Refusal of Planning Permission

Reference: H11-0434-15 Received: 14th May 2015

Description: Residential development - erection of four dwellings

Location : Swapcoat Lane Long Sutton
Spalding Lincs

1:200 SD15-004/1
DEC-08 B.GILHAM.

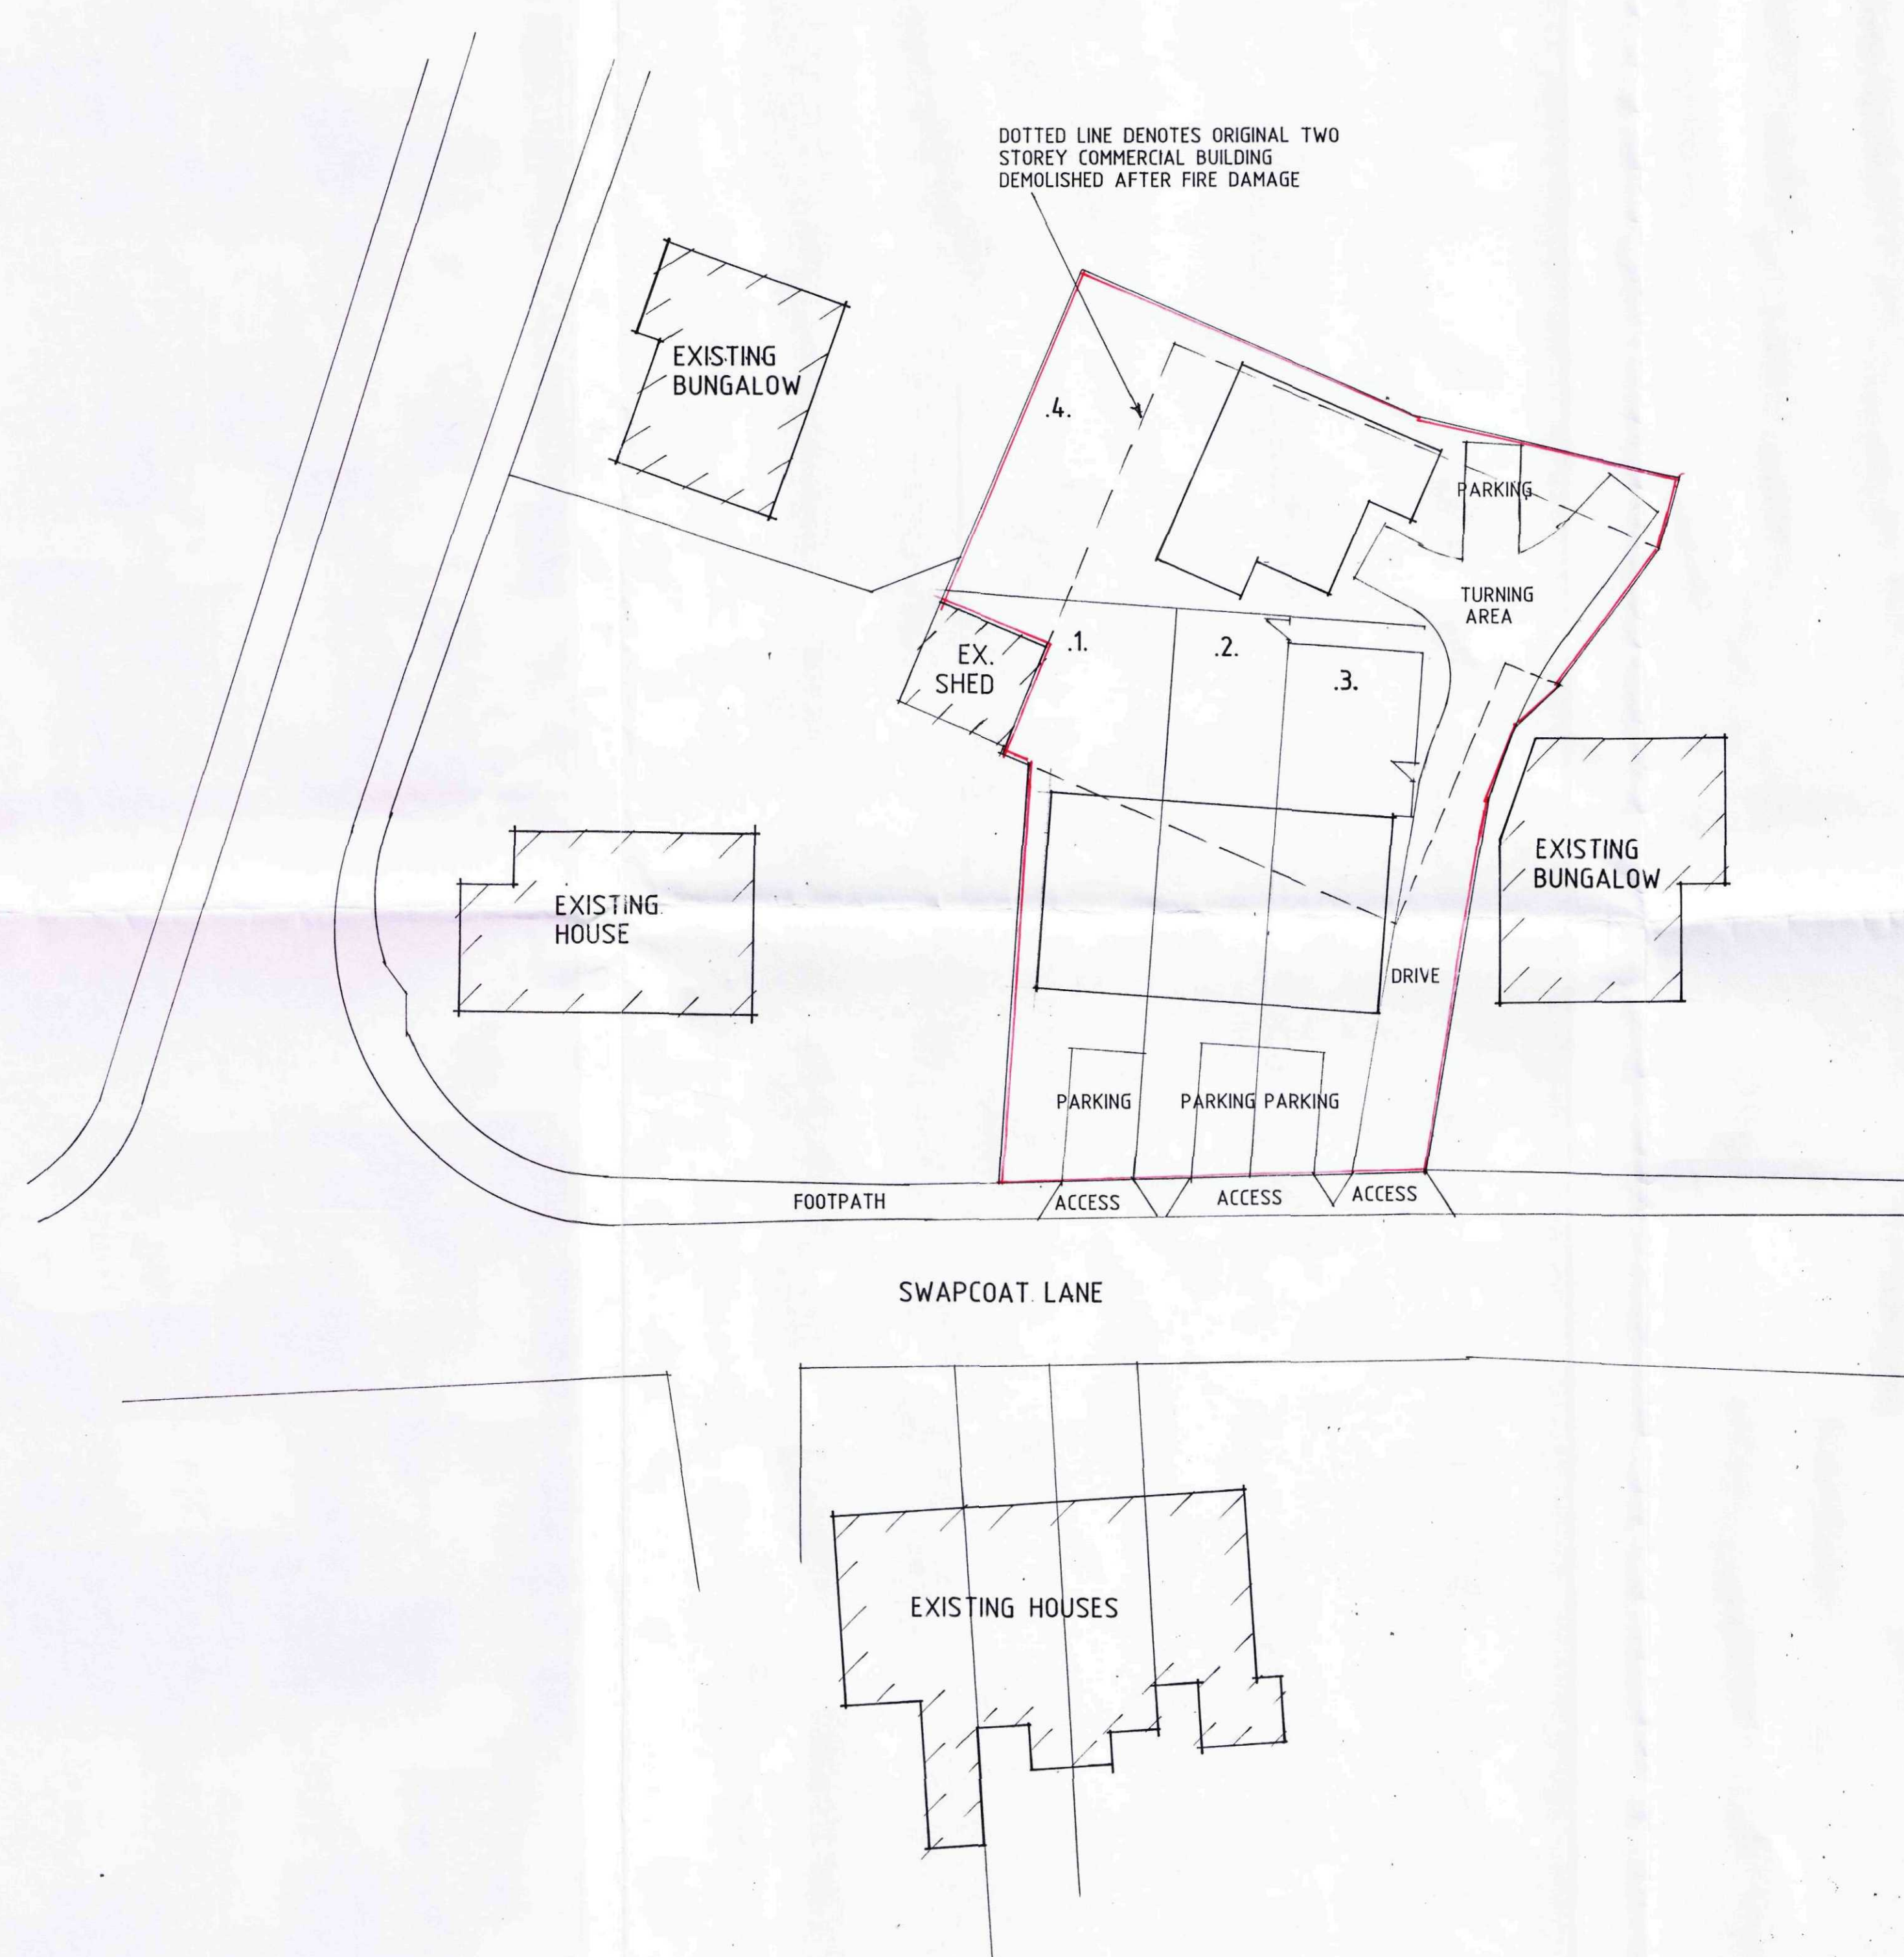
- 1 The proposal to develop the site with 4 dwellings would constitute overdevelopment resulting in an unacceptable form of development contrary to Policy SG14 of the South Holland Local Plan 2006 and Section 7 of the National Planning Policy Framework.
